Post Hearing Submissions and Response to Deadline 4 Submissions
ELMESTHORPE PARISH COUNCIL
9th February 2024

1. Introduction

Written Statement of Oral Case ISH2 [Appendix I - Accessibility Plans for Burbage Common Road]

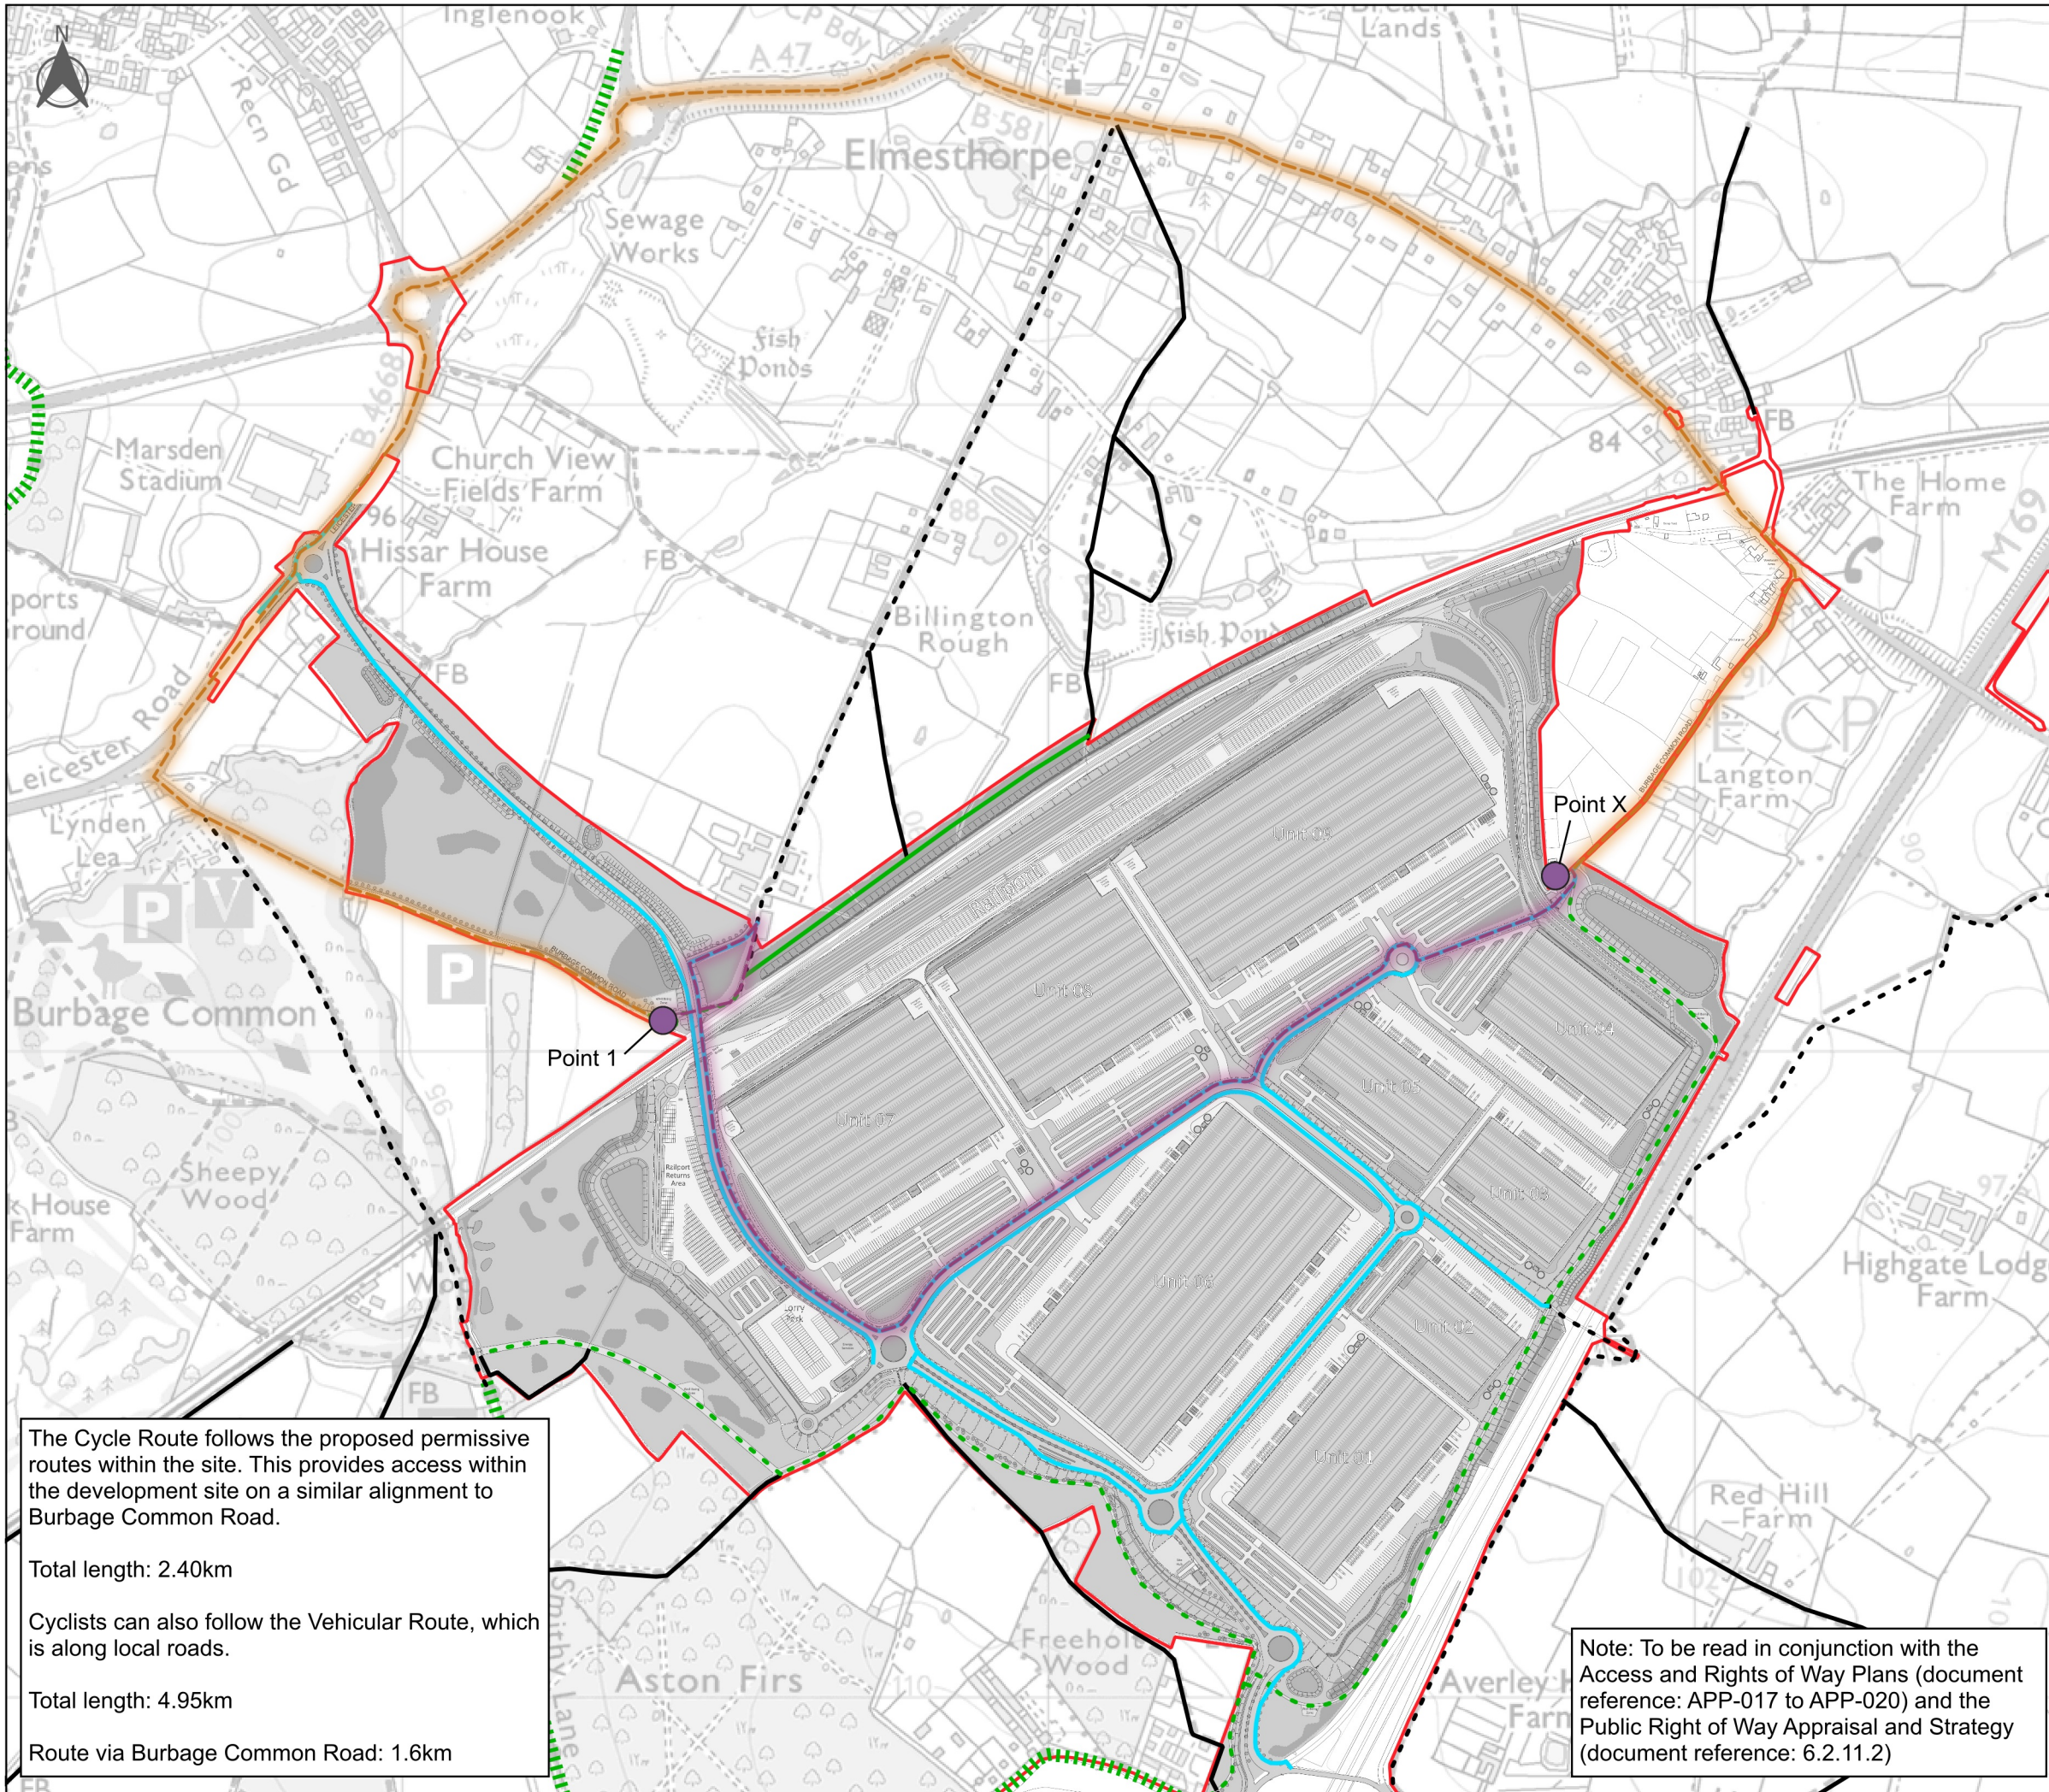
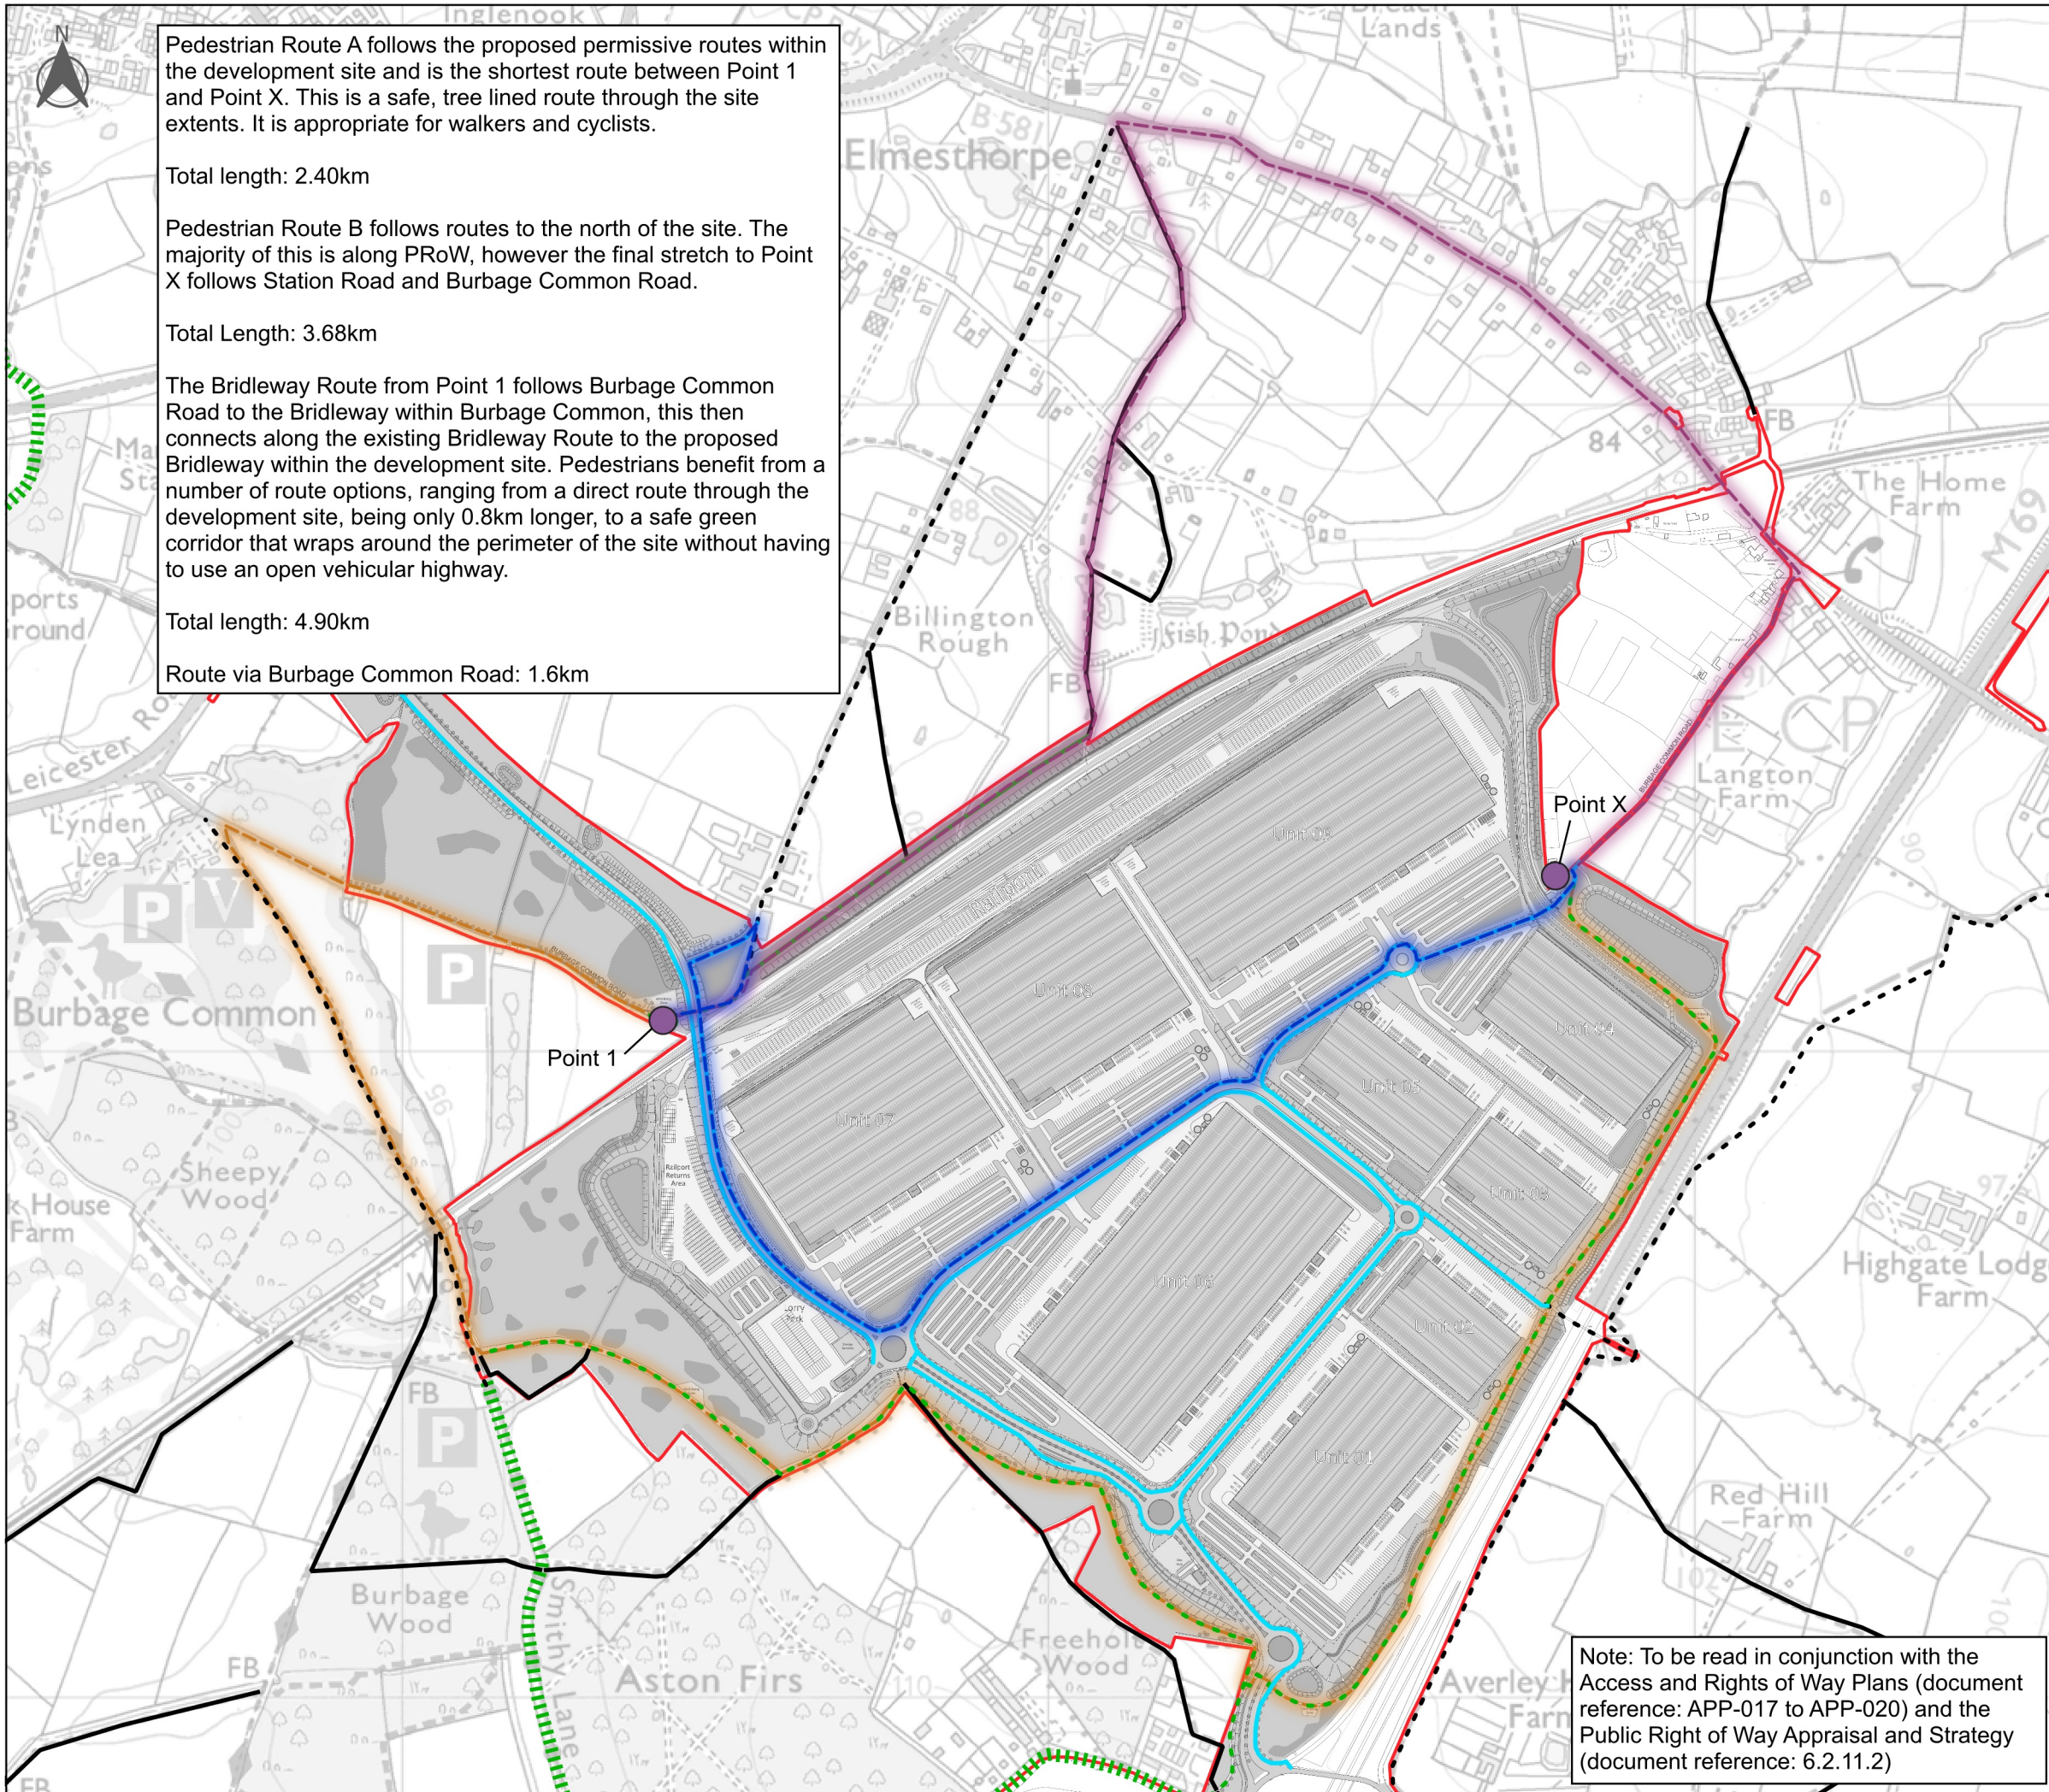
- 8.2. The Applicant has provided us with the details of the two alternative circular routes that will be available once the proposed RFI is completed. Please see appendix 3.

- 8.3. The first alternative circular route is 5.45miles/8.77km (incorrectly annotated as 8.74km on their map). This route travels mostly down the A47 link road and is an undesirable route. The increase to the existing route is +1.32miles/2.12km

- 8.4. The second alternative circular route is 6.35 miles long/10.2km. This route is more comparable with the amenity experienced with the current circular walk, and would be more desirable in terms of the surroundings within the limitations of the new surroundings. The increase to the existing route is +2.22miles/+3.57kms

9. The increase in the length of the alternative PRowS is really quite long, and for some, now too long. As well as the decrease in amenity value of our PRow, they are now more inaccessible to those with mobility issues, small children, poor health or simply just the time constraints of daily life.
